**Our ref: NO/2025/116713/01-L02**  
**LPA ref:** 3/2025/0107  
**Date:** 23 April 2025

**RETENTION OF TWO HOLIDAY LODGES AND OFFICE BUILDING WITH  
ASSOCIATED PARKING, INFRASTRUCTURE AND ALTERATIONS.  
BOADICEA PARK, PRESTON ROAD, RIBCHESTER, PR3 3XL**

#### Detached Warehouse Quality Control Office

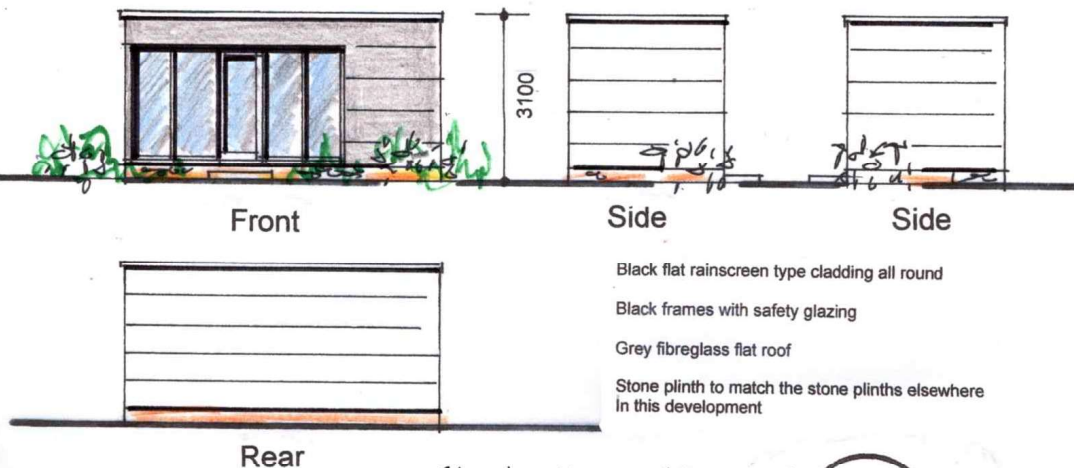
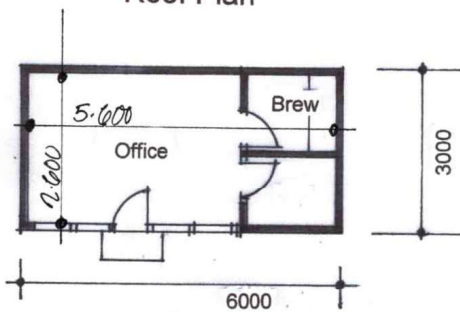
Unfortunately, the flood map for the development site has changed since our earlier responses to the original application 3/2021/0595. The new office block has been located in an area of the site now currently designated as Flood Zone 3 on the Environment Agency's recently updated Flood Map for Planning. Flood Zone 3 represents a high risk of flooding, we therefore need to update our formal comments to this application.

In the absence of a flood risk assessment (FRA), we object to this application and recommend that planning permission is refused.

The application site lies within Flood Zone 3, which is land defined by the planning practice guidance as having a high probability of flooding. The National Planning Policy Framework (paragraph 181, footnote 63) states that an FRA must be submitted when development is proposed in such locations.

Alternatively, there are parts of the development site that fall within Flood Zone 1 within the site boundary, given the modular nature of the new office building, it may be possible to relocate the office unit to a part of the site at lower risk of flooding, in which case an FRA would not be required.

To overcome our objection, the applicant should submit an FRA which demonstrates that the development is safe without increasing risk elsewhere. Where possible, it should reduce flood risk overall.
